Re: Planning Application 18/0973

Address: The Avenue Hotel Gleneagles Drive Brockhall Village Old Langho BB6 8AY

Description: Single storey extension to bar and dining area (resubmission of application 3/2018/0533).

title
Existing & Proposed Site Plan
scale 1:200 drawn AF date 02/05/18
drwg. no 18/2293/04 rev. D

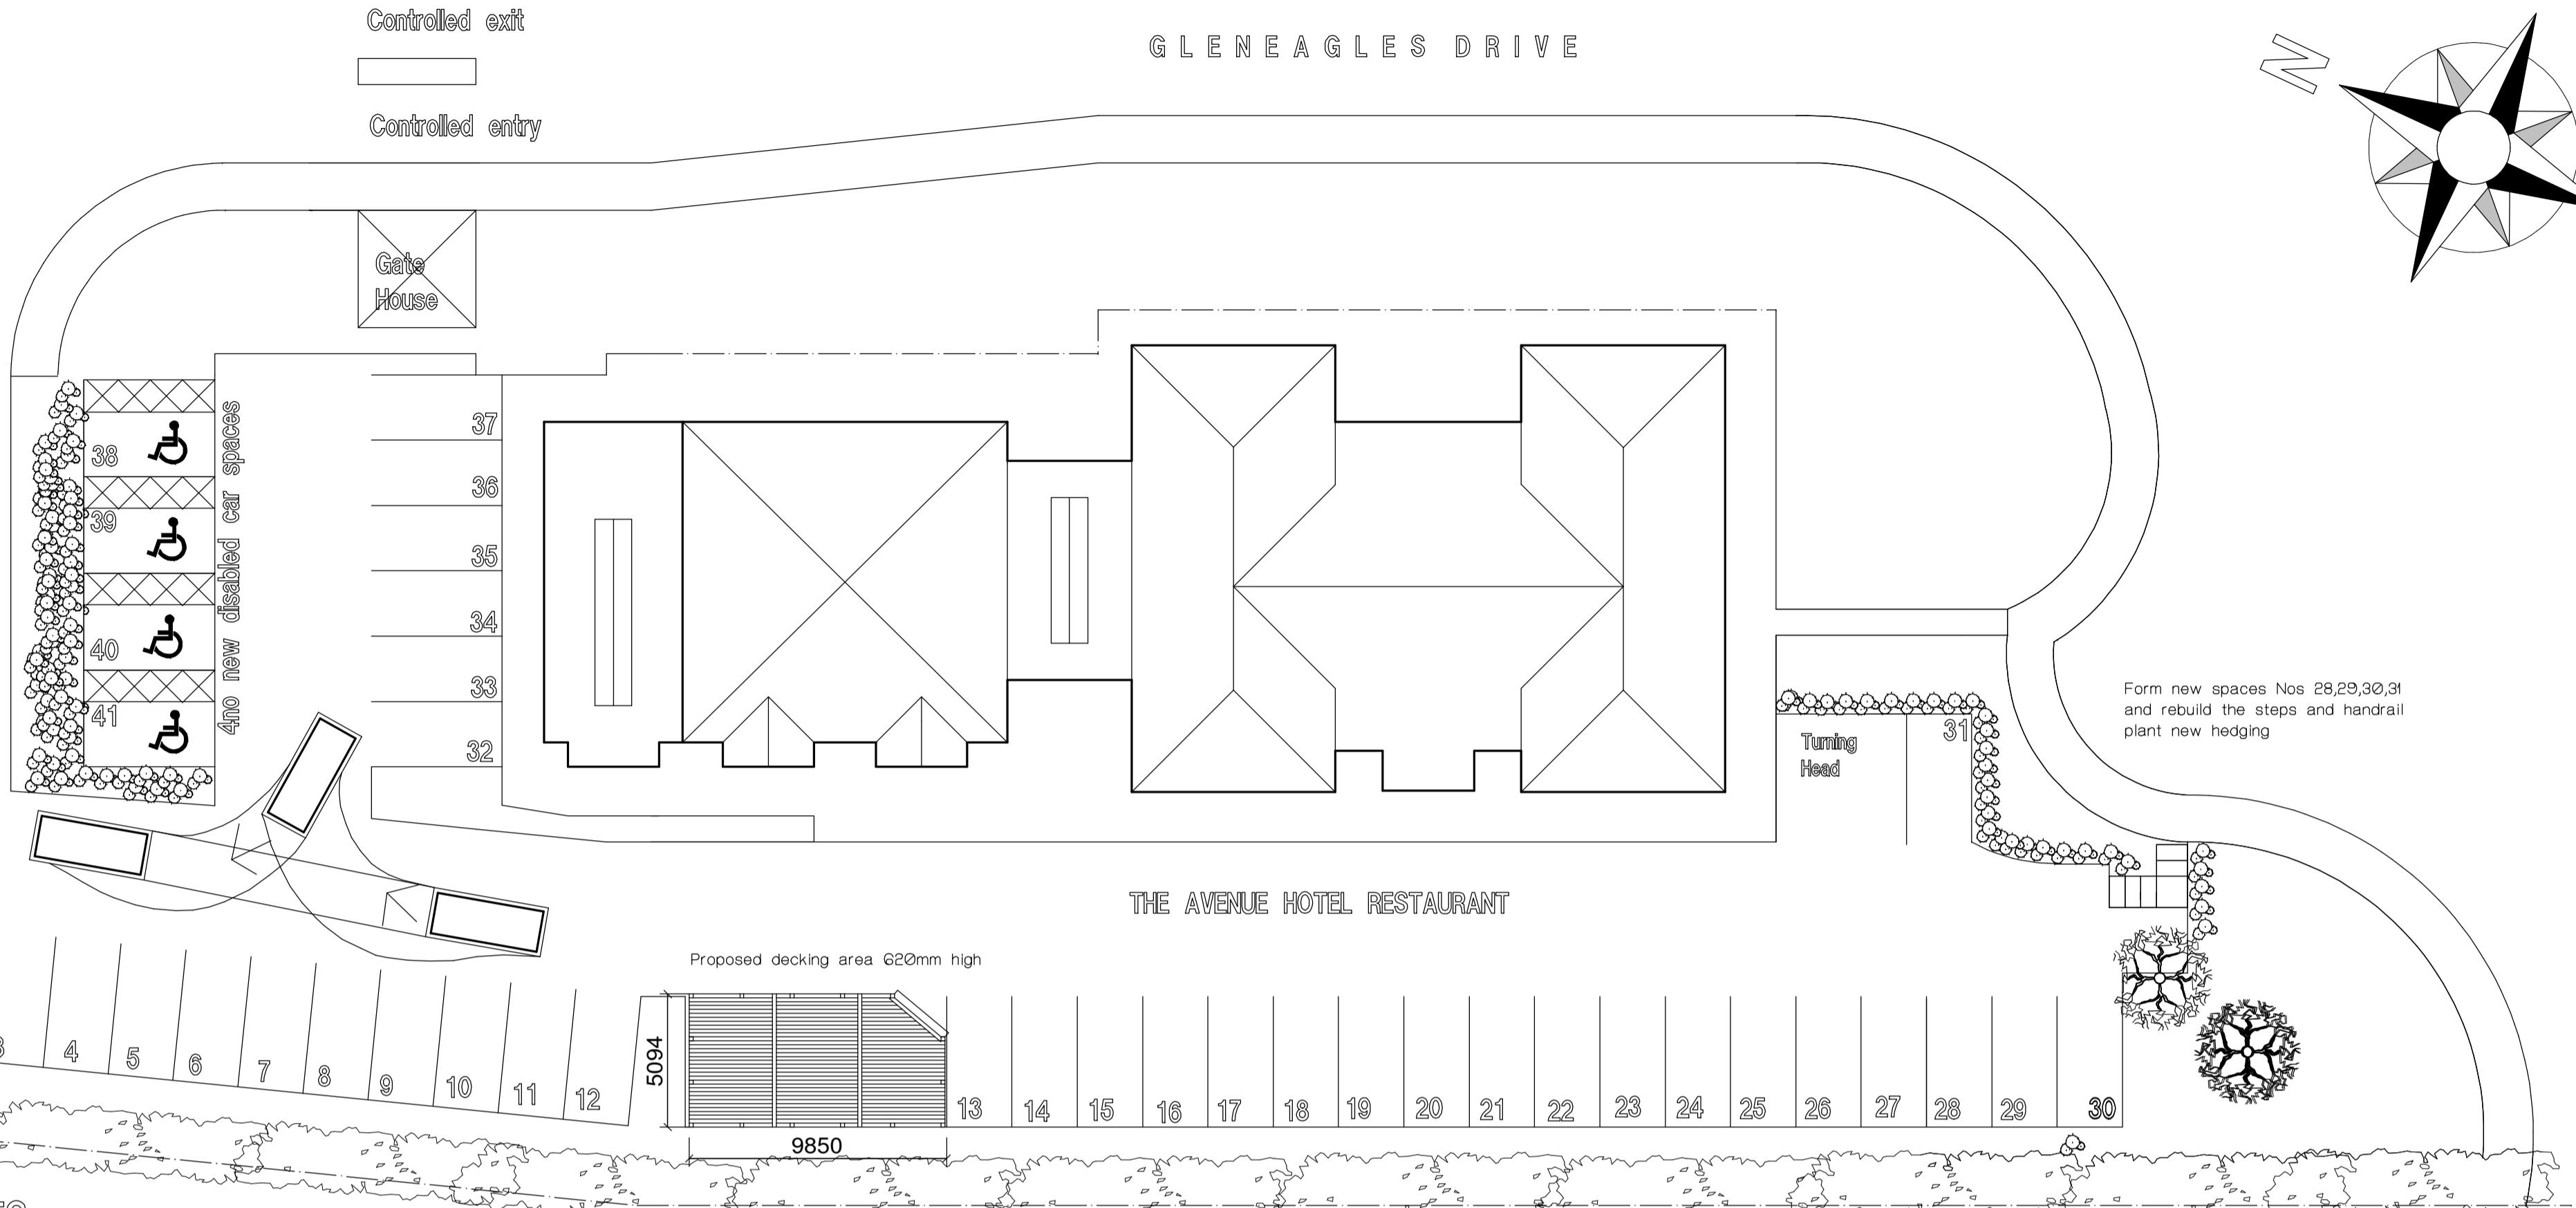
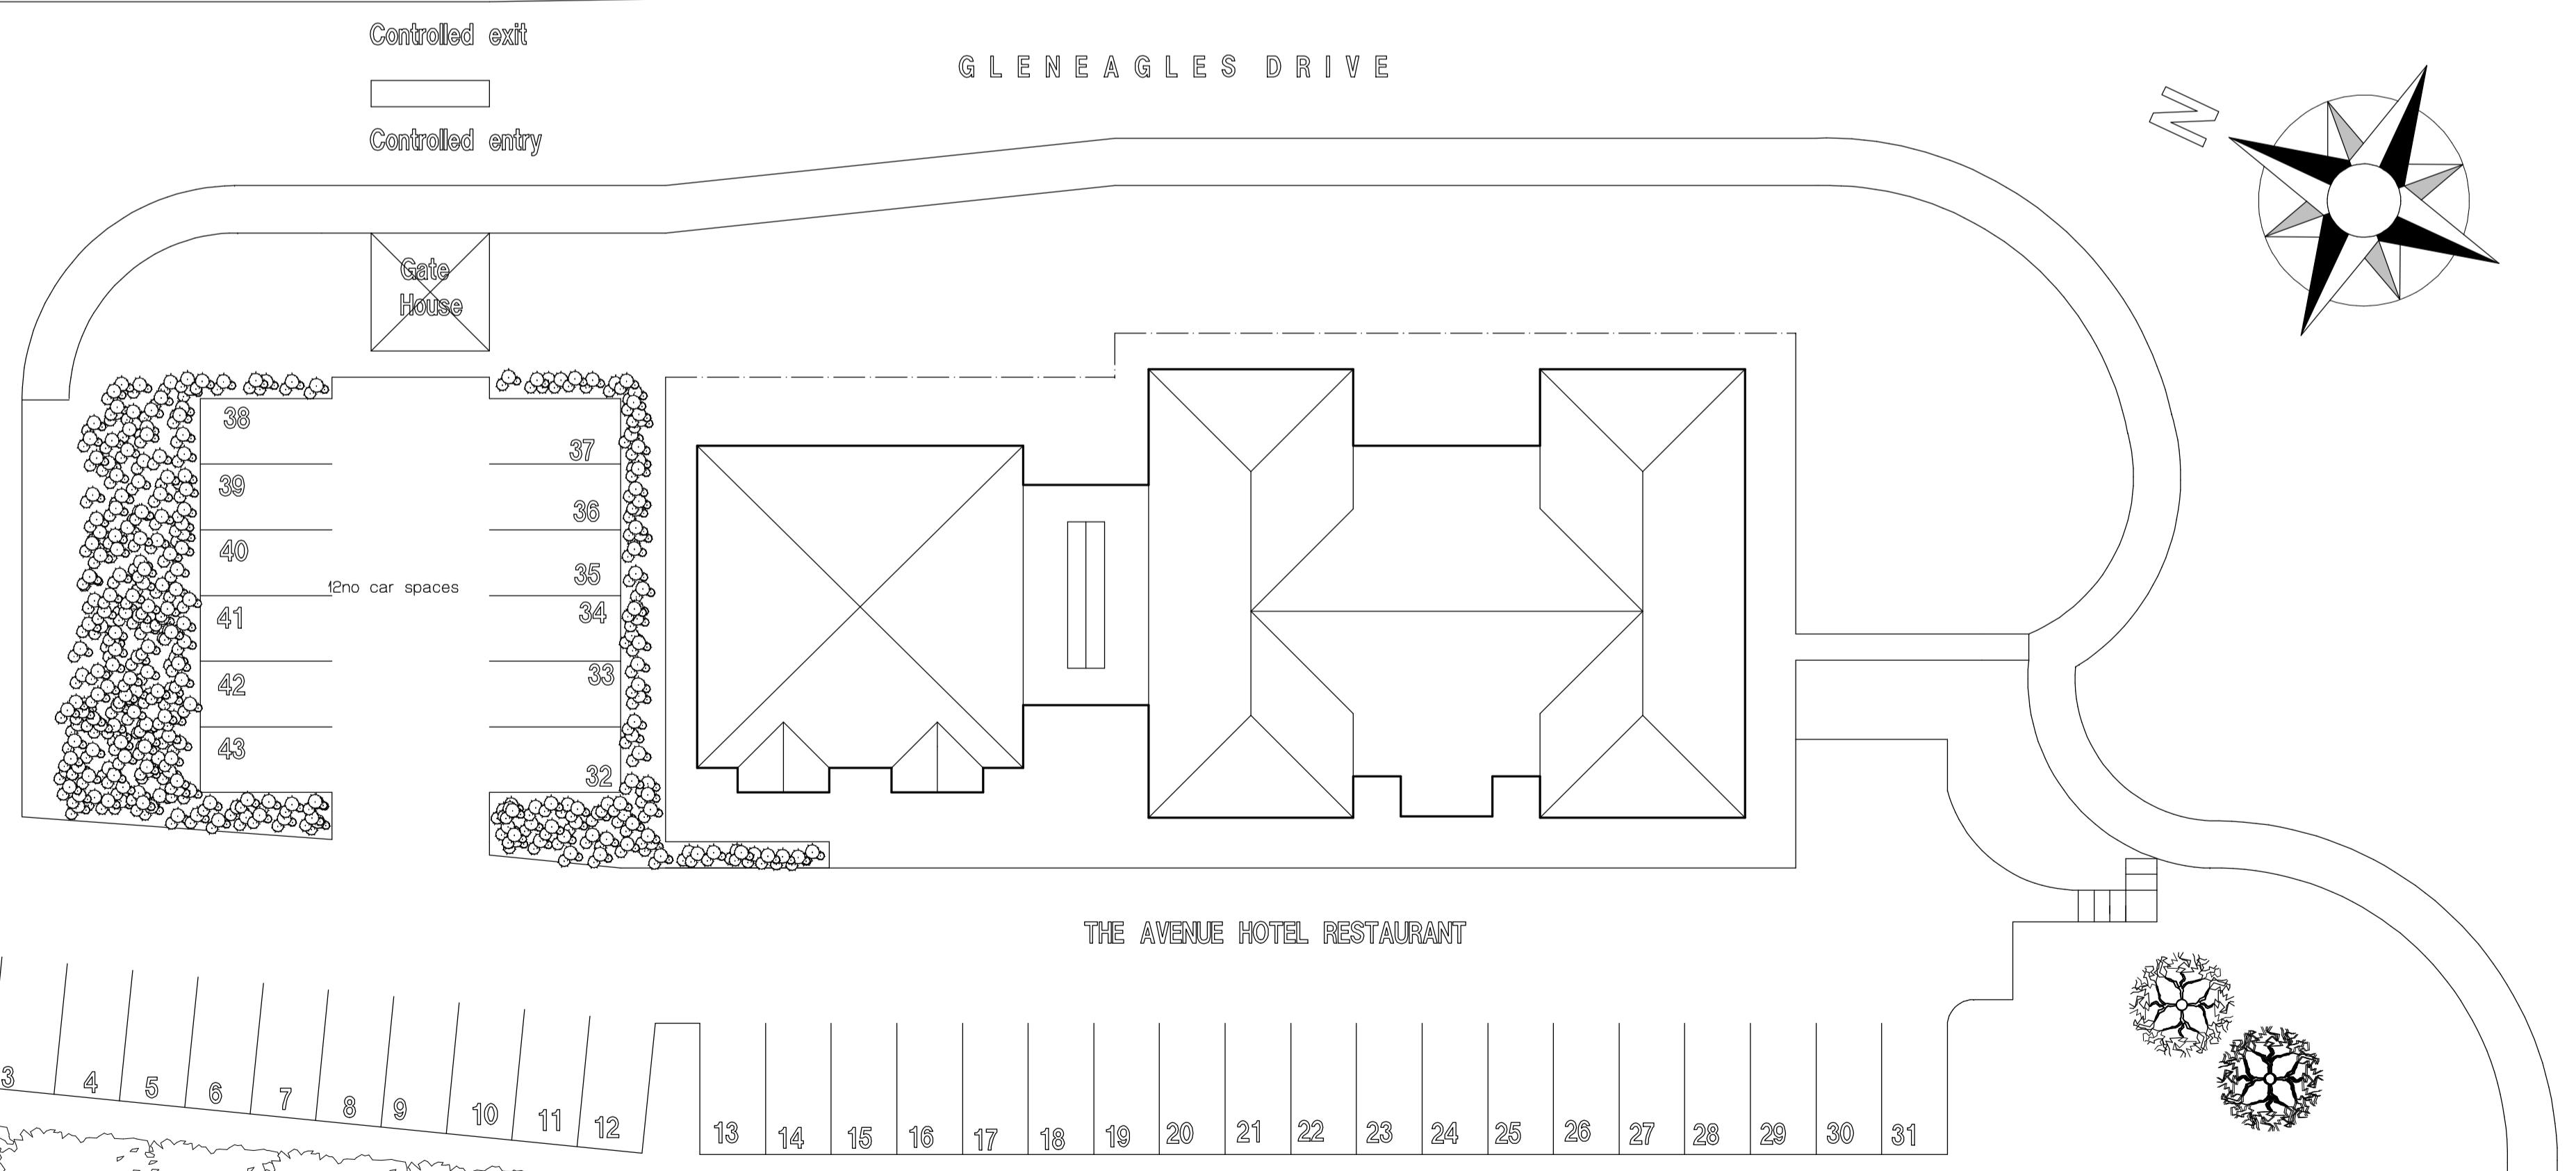
Following some amendments to the earlier provision the concerns regarding the turning head and the mobility parking have been allayed.
